Re: Structural Design and Construction Report – Zone A

Project: Greystanes Public School (PS)

Drawing No: • S001-A, S025-C, S040-B, S050-A, S060-A, S080-B, S100-E, S105-A, S106-F, S110-B, S115-B, S116-B, S117-B, S118-B.

ON SITE DETENTION TANK 2 DETAIL

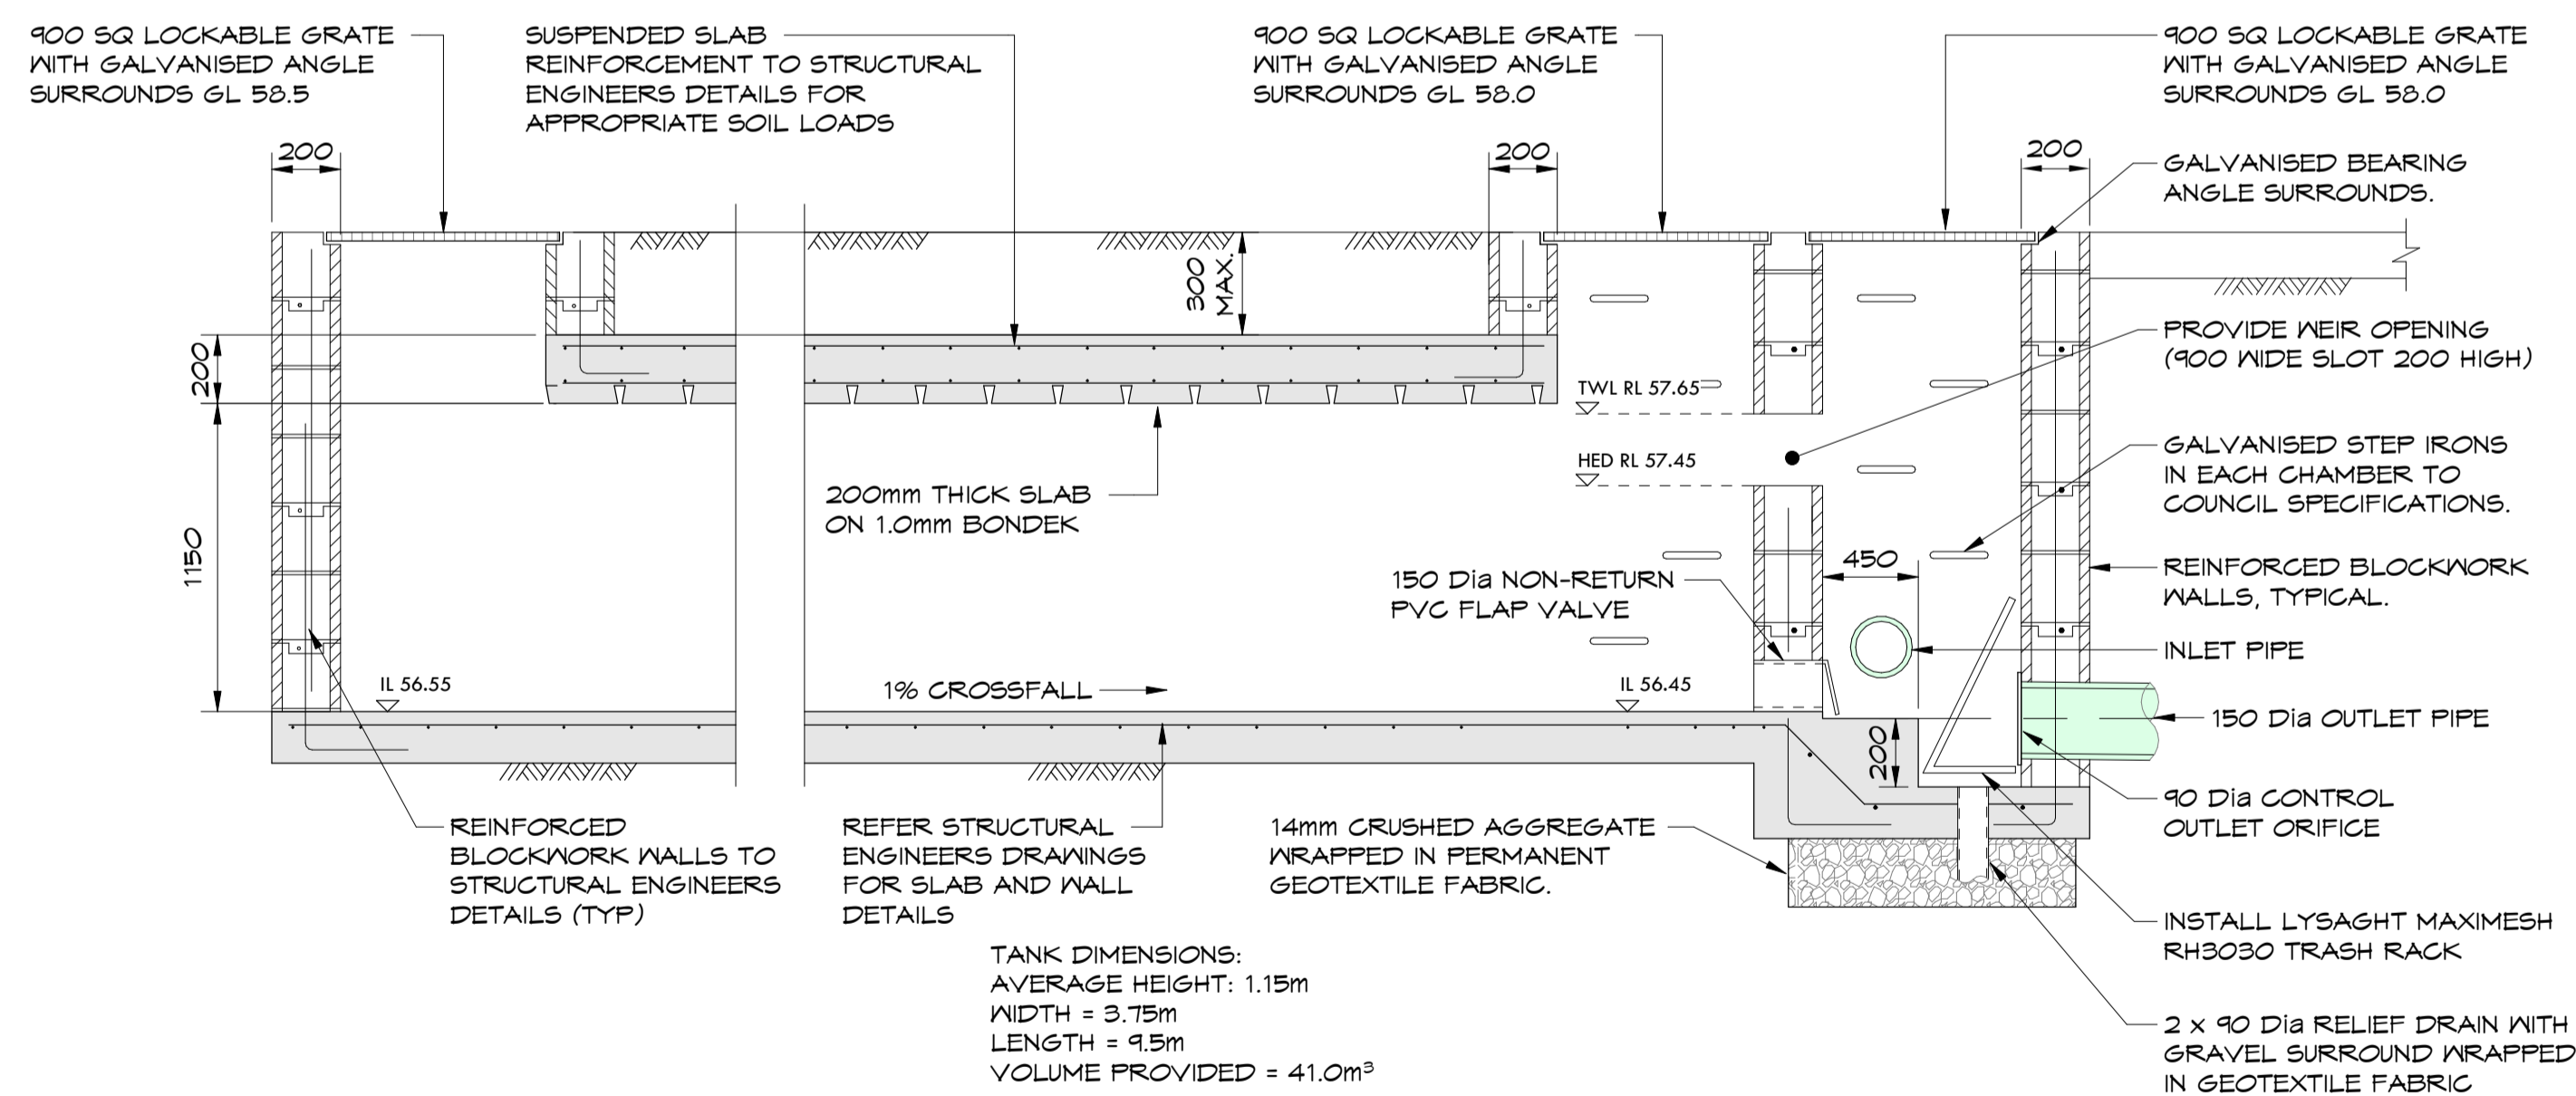
- 1) Mesh to be lapped 300 mm min.
Extend / relocate mesh as required.
- 2) Starter bars for Drisel wall @ perimeter & @ sump pit not installed yet.
- 3) 'Z' Bars around sump pit not installed yet
- 4) Clean perimeter area from natural soil / gravel to ensure cover maintained to edge beams (side + bottom cover)

- 1) Install 2N12 trimmer bars @ top every re-entrant corner how long.
- 2) Install additional 2N16 Bars (1500 long) on top of dished wall @ middle part of ASD Both ways

- 1) At 'T' Junctions of Drilled wall, install vertical bars w/'U' horizontal bars @ 300 centres

- 2) Add vertical bar & 'L' Bar N16 at this location
- 3) 'U' Bar @ top need to extend all the way to long wall elevation.

Confirming this closes out the report.

It appears the outstanding items have been rectified as per our site instruction report.

Confirming this closes out the report.
